REQUEST

Current Zoning: UMUD-O (uptown mixed use, optional)
Proposed Zoning: UMUD-O SPA (uptown mixed use, optional, site plan amendment)

The petition proposes to modify an approved plan to allow additional signage for the Hearst Tower in Uptown.

#### **REZONING PETITION 2020-xxx**

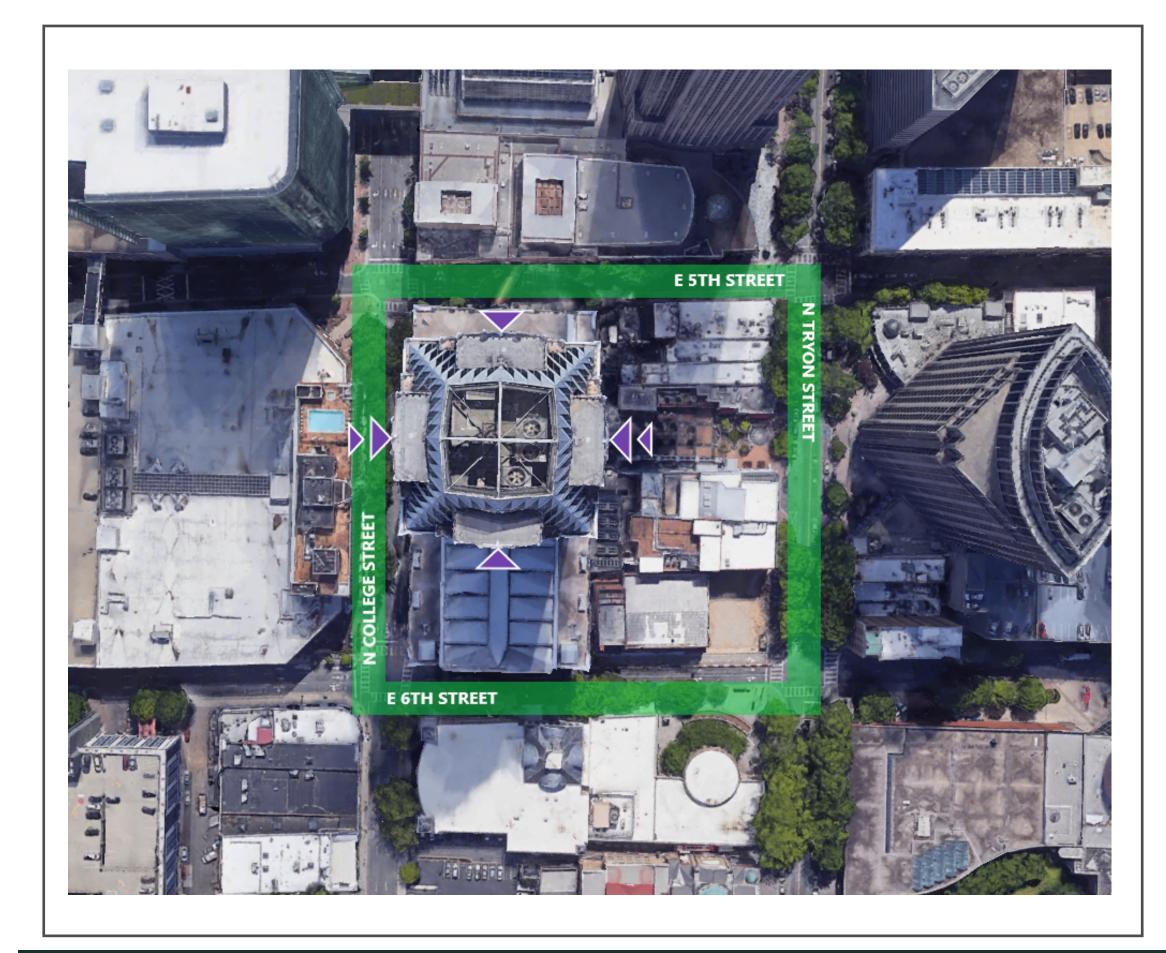
1. Label each sheet 2020-064. Addressed
 2. Note proposed zoning is UMUD-O SPA. Addressed
 3. Place signage optional provision request on the site plan. Addressed
 4. Update ownership information on the site plan. Addressed
 5. Ensure optional provision language references the correct chapter in the ordinance. Addressed
 6. Ensure all entitlements under 2001-076 are noted in this plan. Addressed
 7. Remove heading "approved rezoning petition 2001-076" and reference in language. Addressed
-
